DRB CASE NO/PROJECT NO: 1006951

SKETCH PLAT

RE: Tract 1A, Lands of George Sandoval

**Development Review Board 12/5/07 Agenda Item #19
Sketch Plat: Lot 1A, Lands of George Sandoval**

Sketch Plat
 Lots 1A-1 through 1A-5 Inclusive
 being a replat of Lot 1A
 Lands of George Sandoval
 City of Albuquerque
 Bernalillo County, New Mexico
 November 2007

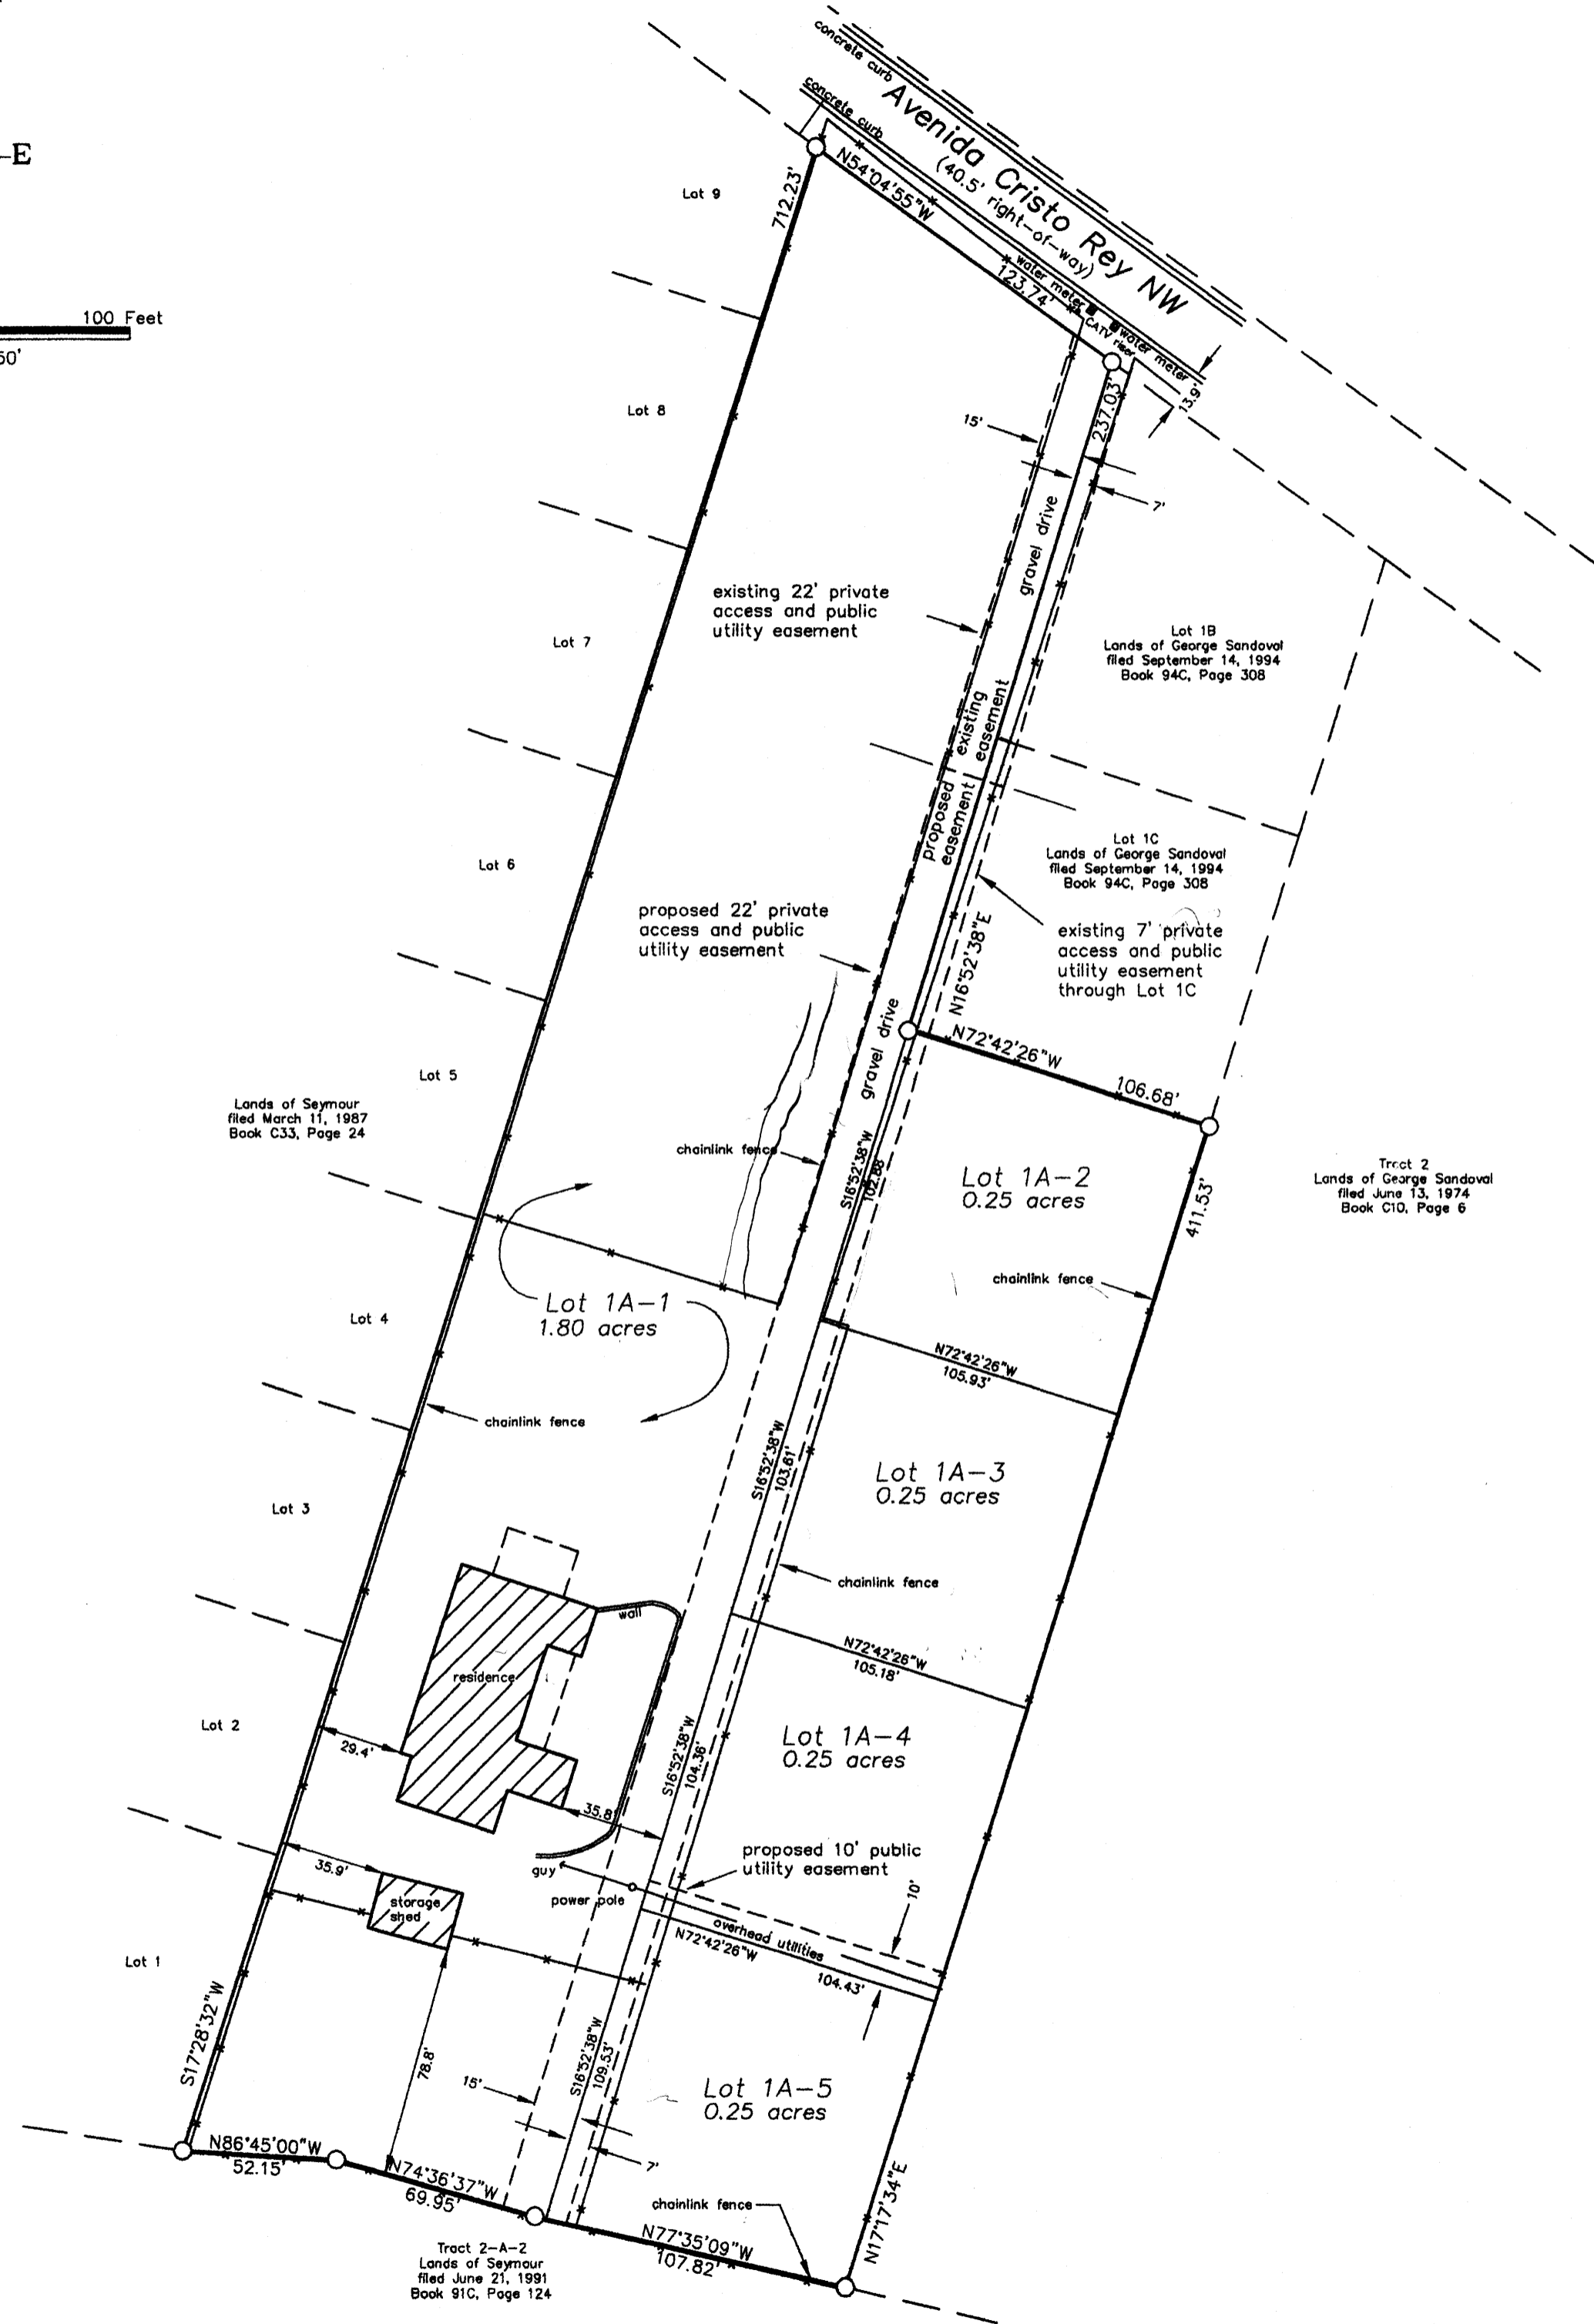
Amend location of proposed 22-foot private access easement; a portion of the area already has a 7-foot private access easement on the adjacent lot – this section would only need an additional 15-foot easement

Refer to comments from Transportation Development regarding minimum access standards.

Minimum .25 acre lot area must be exclusive of access easement(s).

An approved grading and drainage plan is required for Preliminary Plat approval.
